WELWYN HATFIELD BOROUGH COUNCIL – DEVELOPMENT MANAGEMENT
DELEGATED REPORT

APPLICATION No:	S6/2012/1444/FP
APPLICATION Site:	2 Cuffley Gate, Sopers Road

This application seeks full planning permission for the erection for change of use of unit from Use Class B8 (storage and distribution) to Use Class A5 (hot food takeaway)

Drawn	Date	Scale
RDL	May 2012	1:100
Project Number	Drawing Number	Revision
12001	15-01-100	/

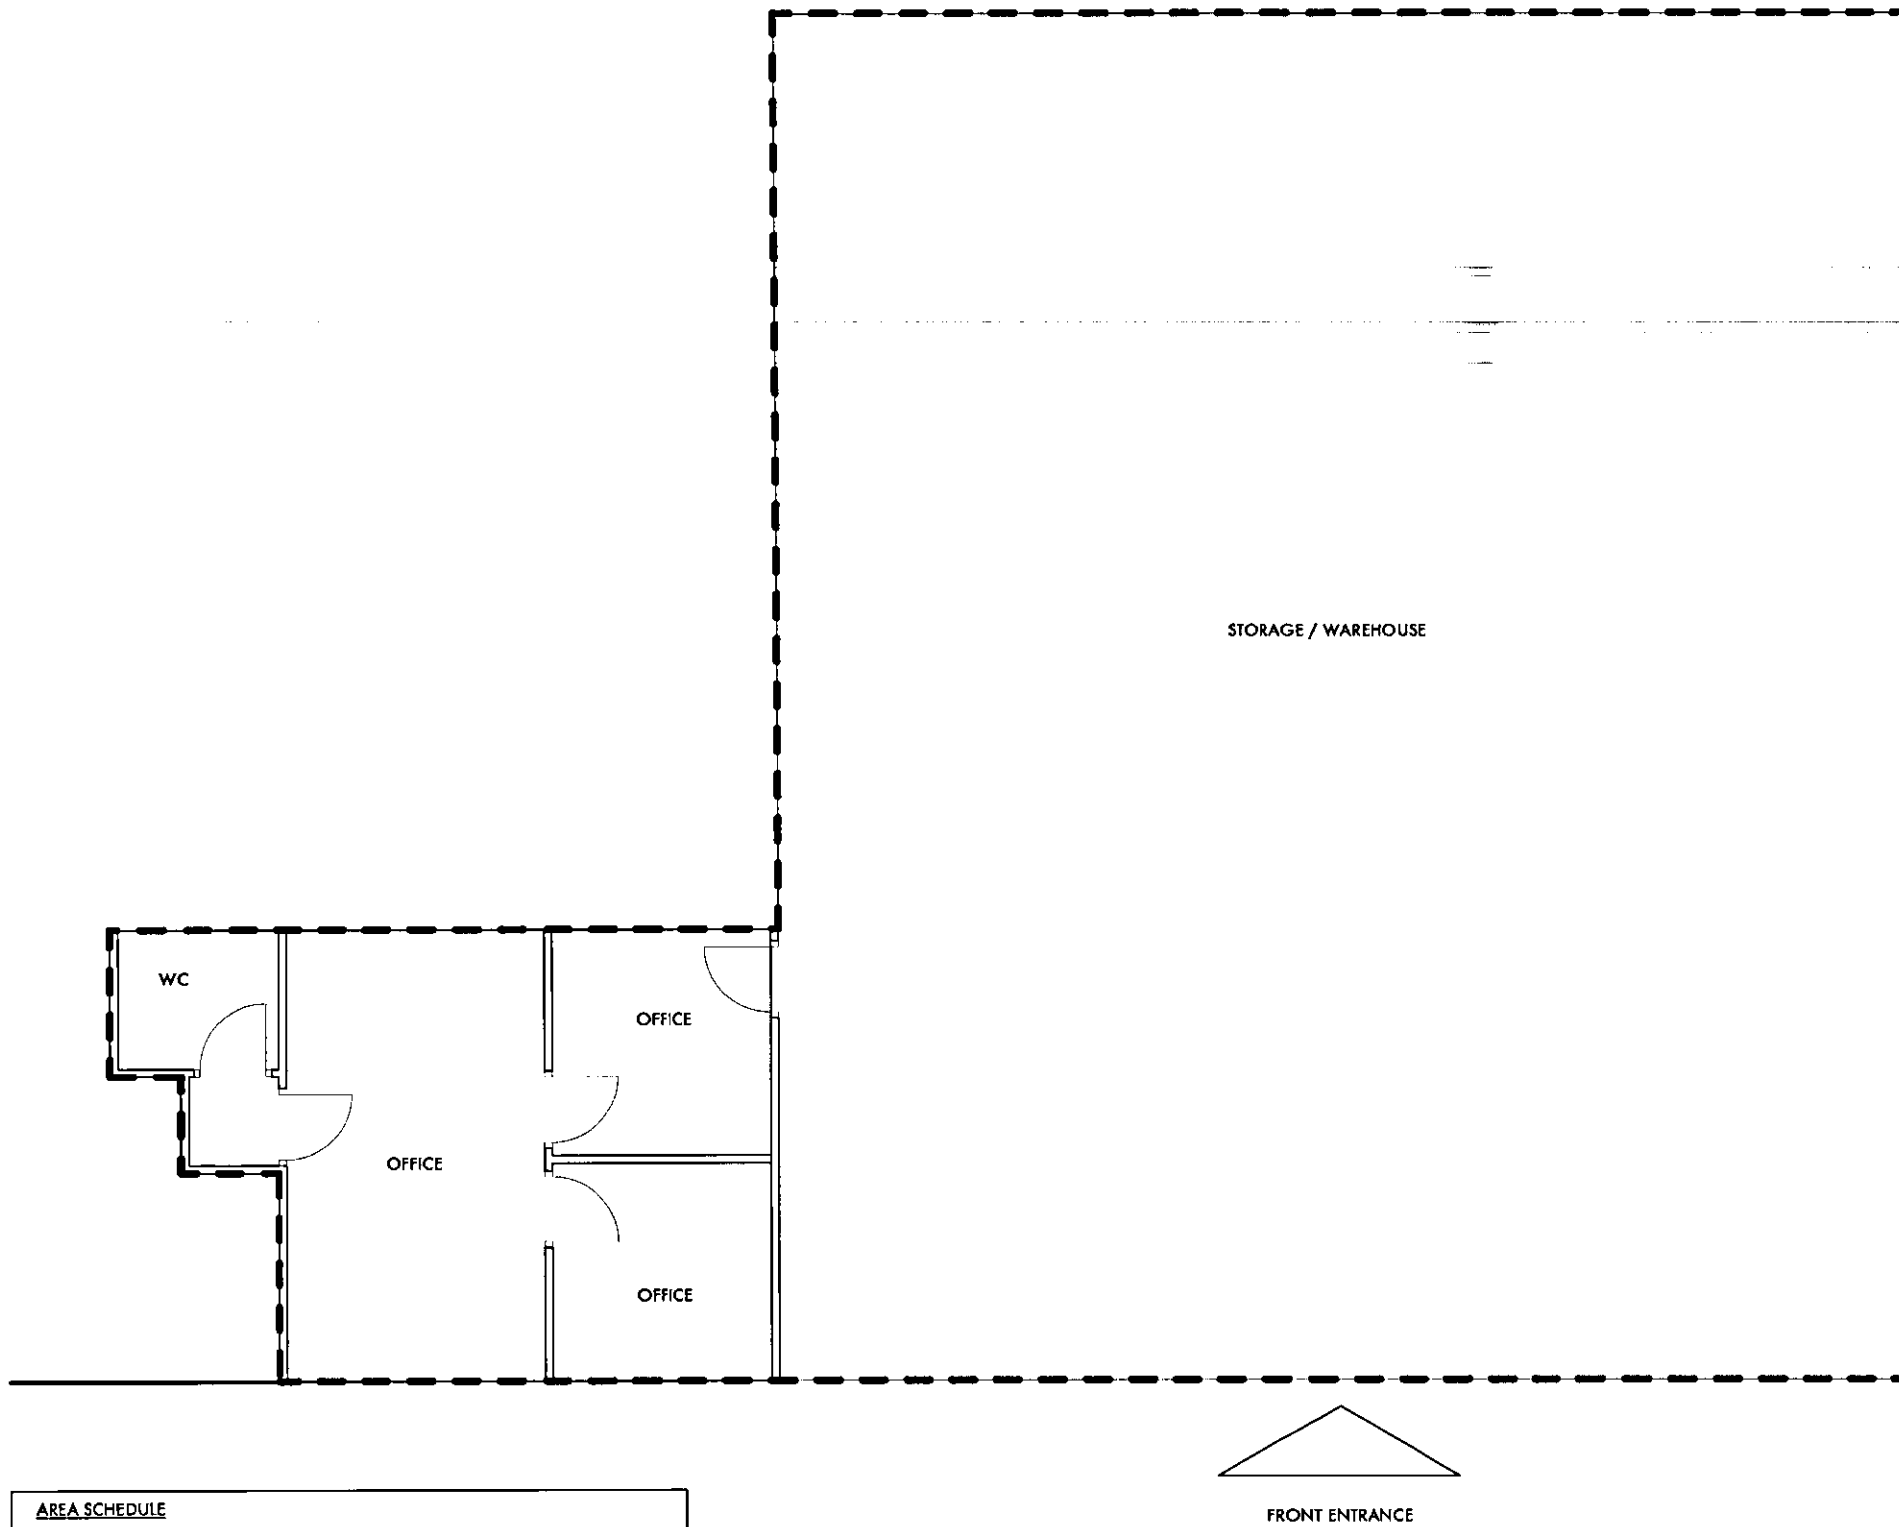
Drawing No.15-01-100 shows an area of approximately 14sqm would be open to the public. The applicant has stated that there are 3 members of staff. Accordingly the proposed use would require approximately 6 car parking spaces.

Project Number	Drawing Number	Revision
12001	15-01-105	A

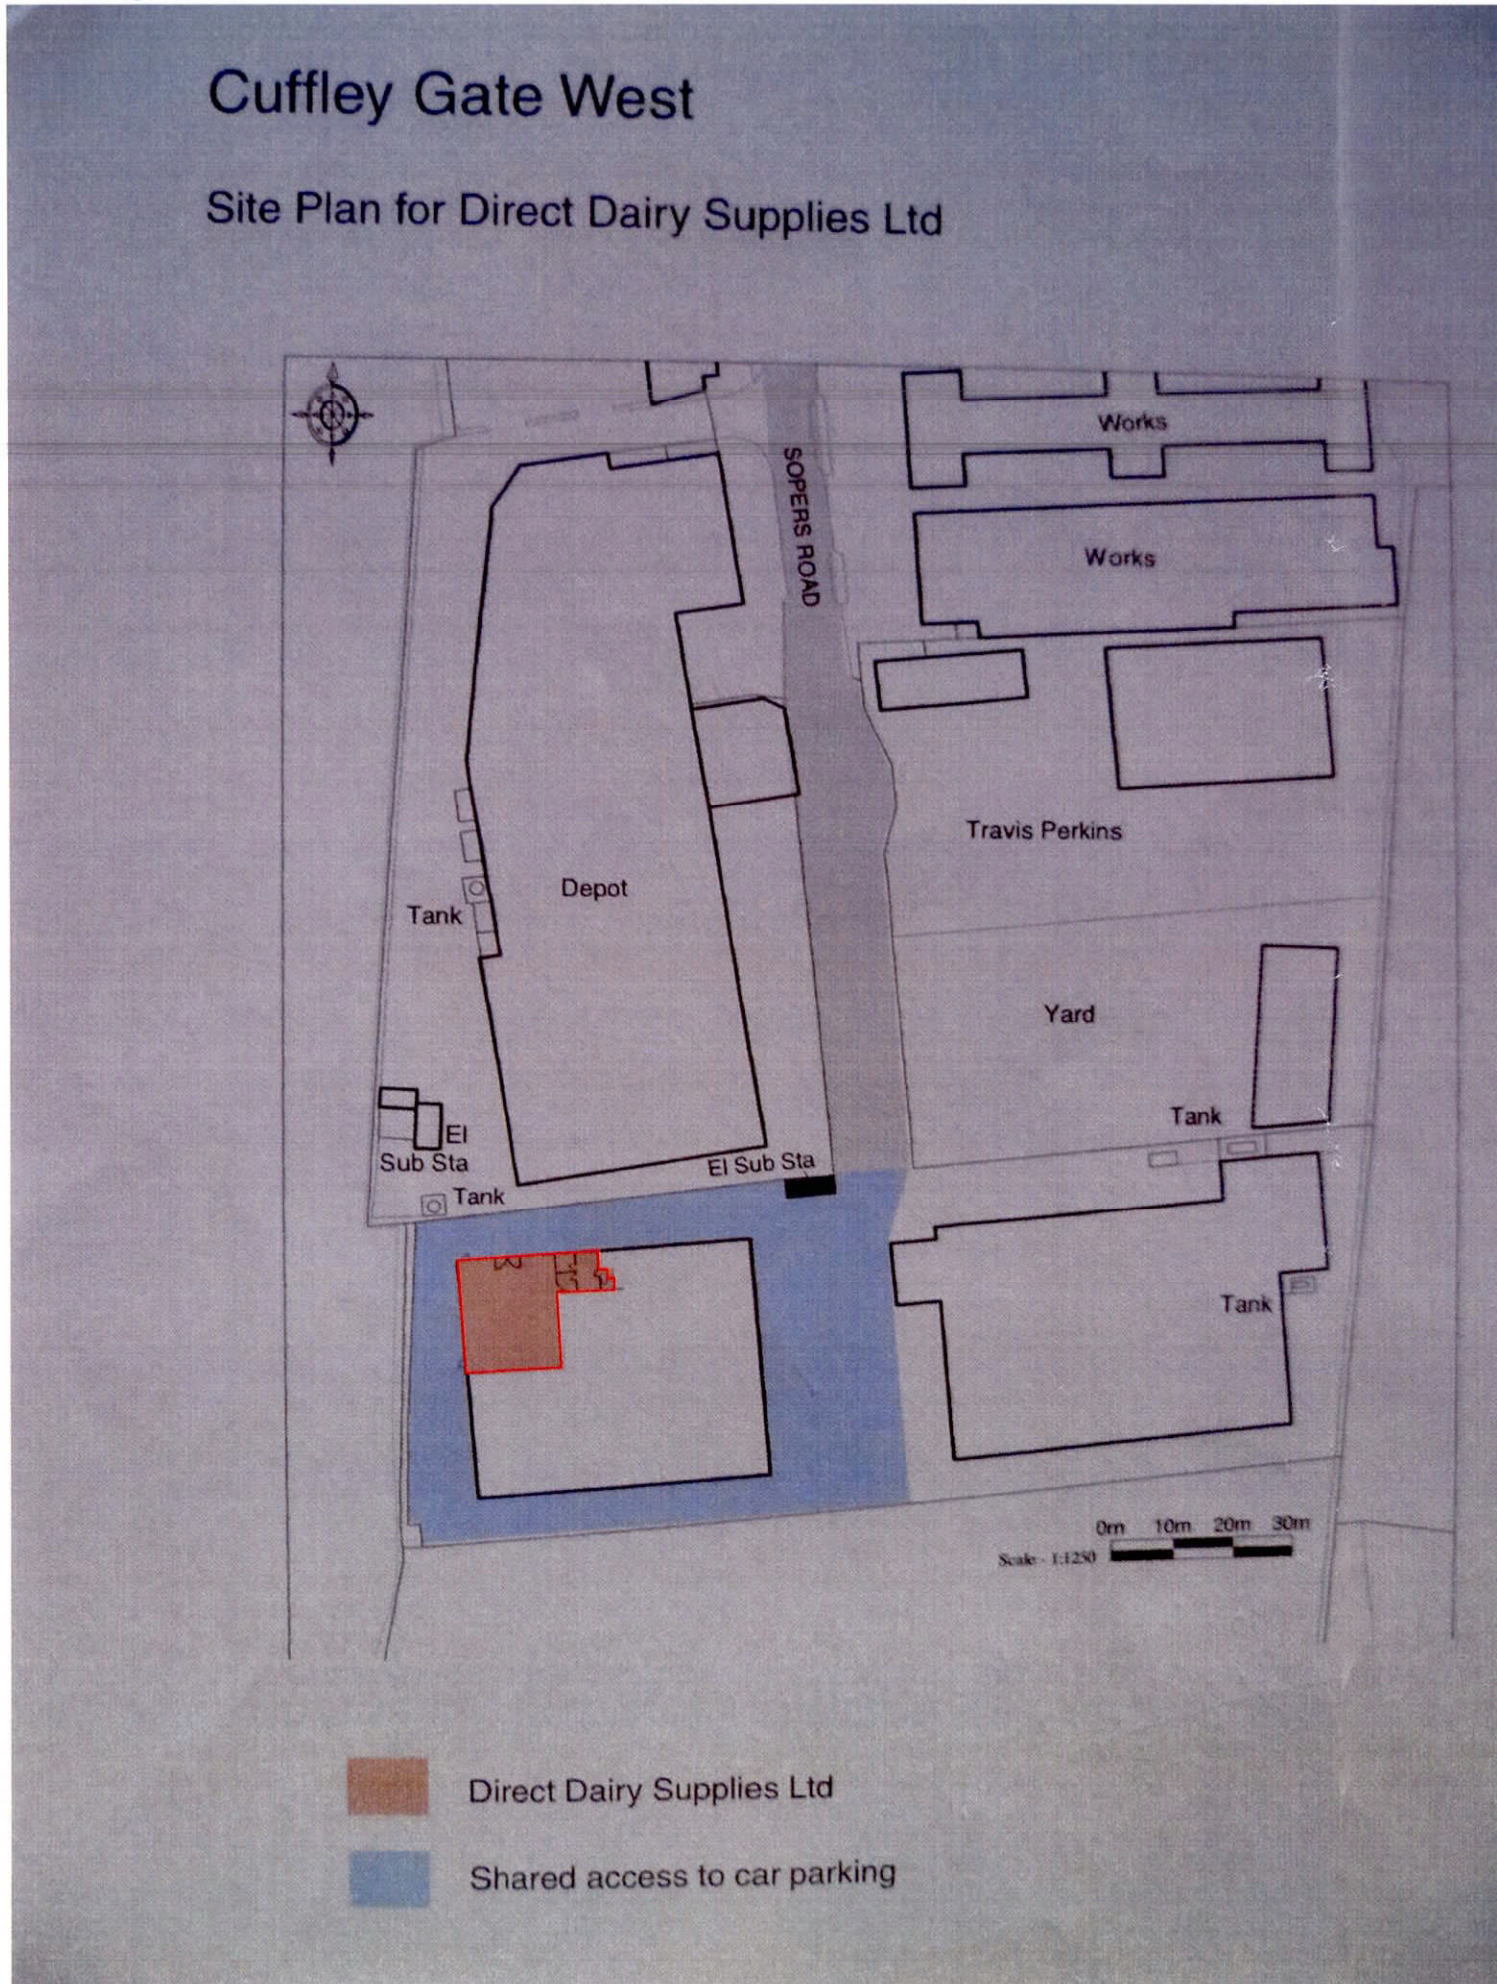
The application form states that 3 parking spaces are available, however, the submitted drawings show only a shared access and parking area with no detail in respect of parking layout or the allocation of spaces. The application unit forms part of a complex of small industrial units and during the site visit there was an articulated lorry being unloaded within the parking area. It was also noted that there was significant pressure for on-street parking within Sopers Road and that the applicant has not demonstrated that there is any cycle parking facilities on the site.

Drawn	Date	Scale
RDL	Sep 2012	1:50
Project Number	Drawing Number	Revision
12001	15-01-107	/
Original Drawing Size A3

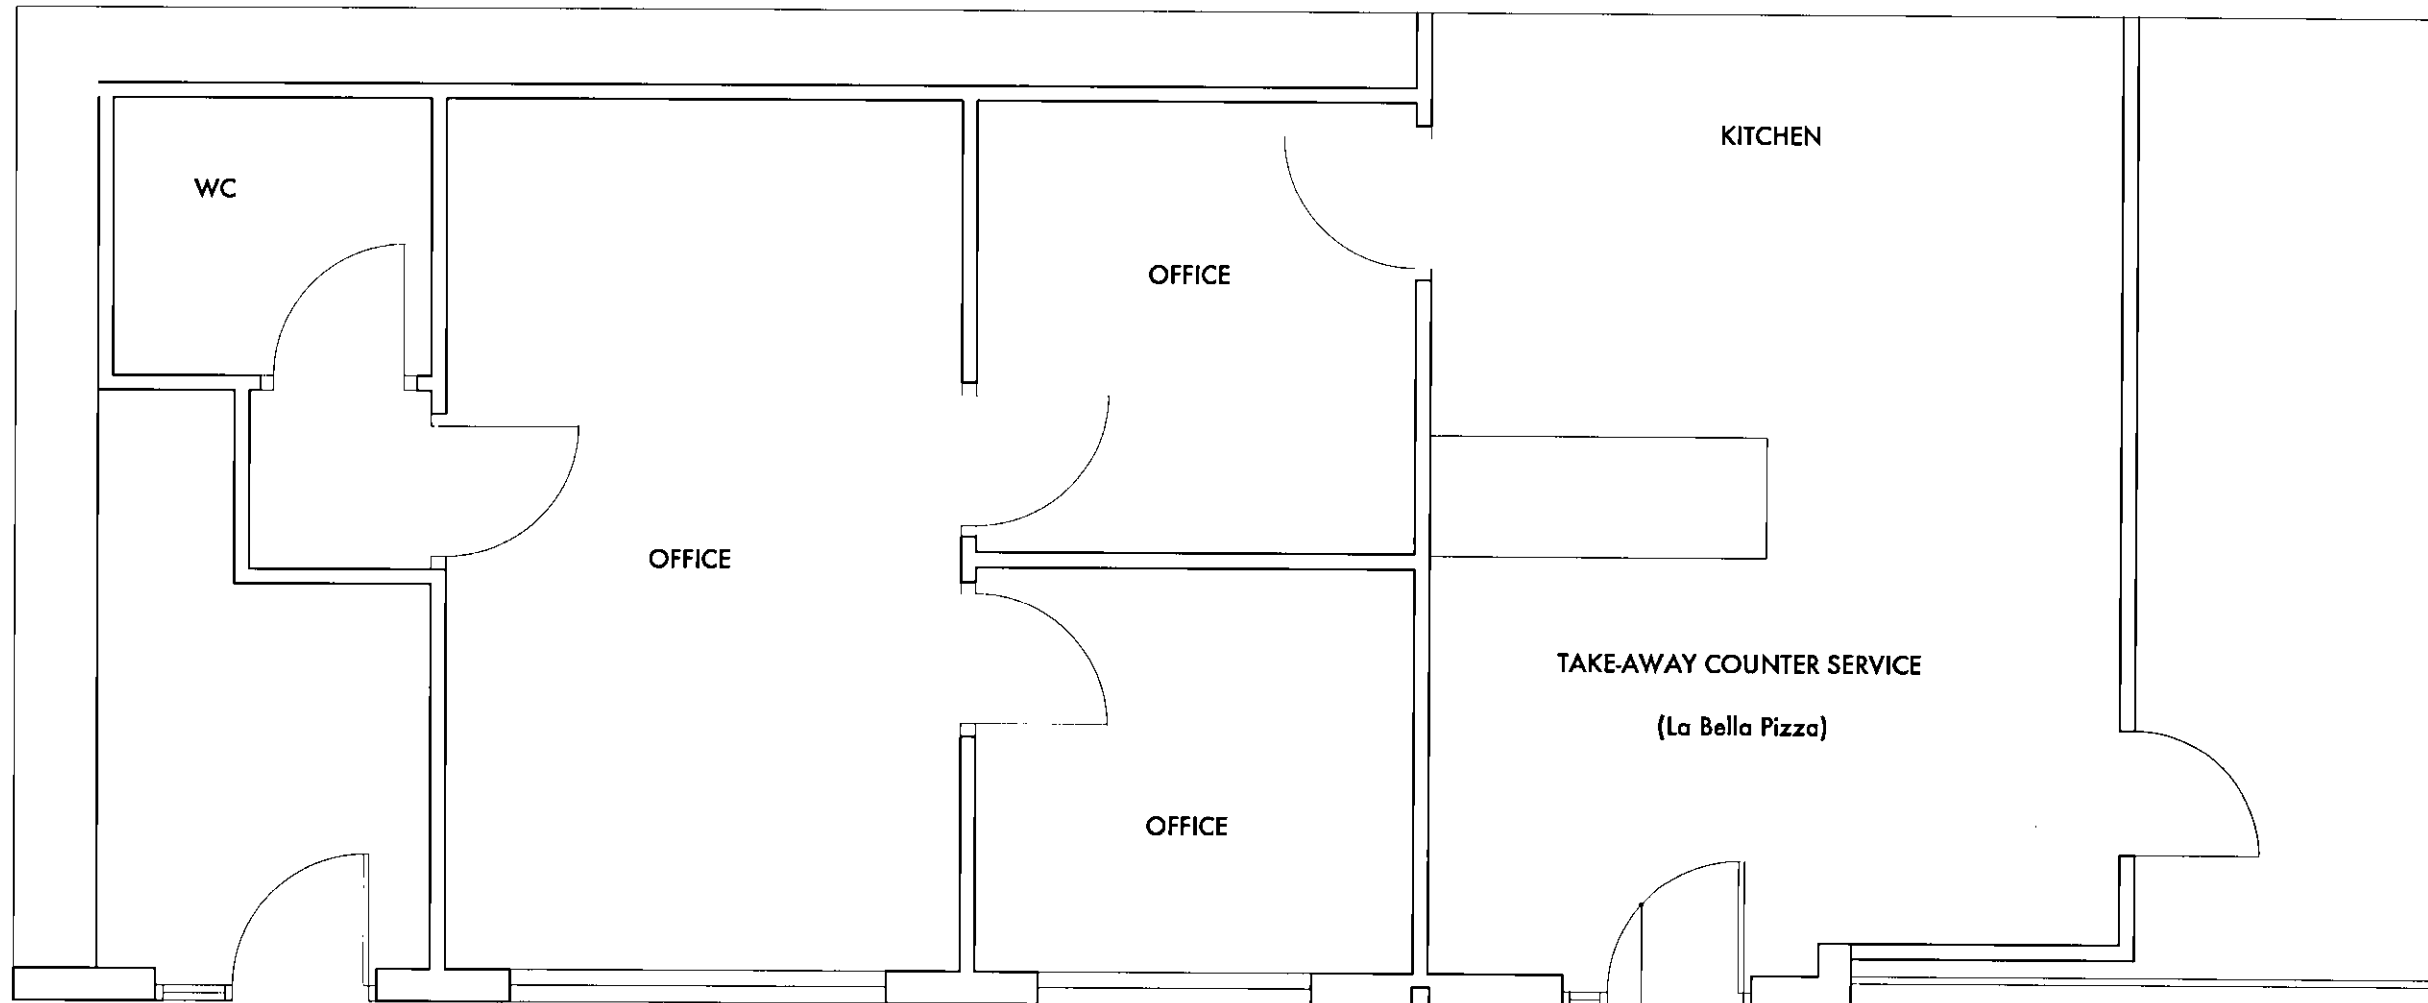
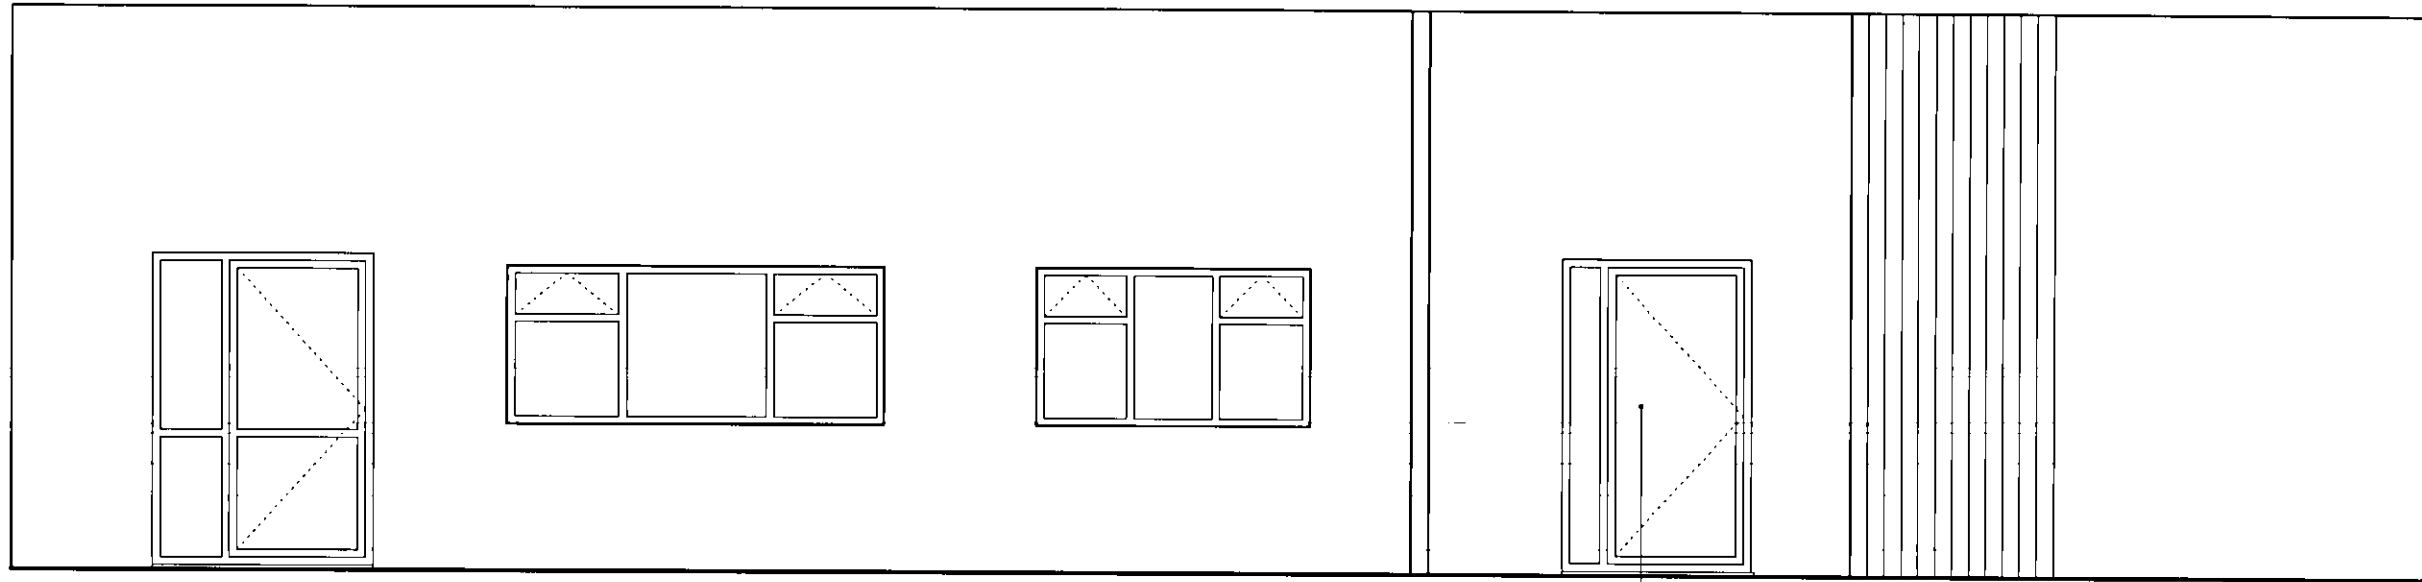
The application was advertised by site notice. One objection was received from Cuffley Cafe on the grounds that the proposed use would “cause unhealthy competition” due to the number of existing restaurants and premises where food is also served. Welwyn Hatfield Access Group commented that the existing entrance does not have level entry and the external footway approaches are both narrow and not level. Also, the proposed elevation drawings do not confirm if the new door would provide level entry.
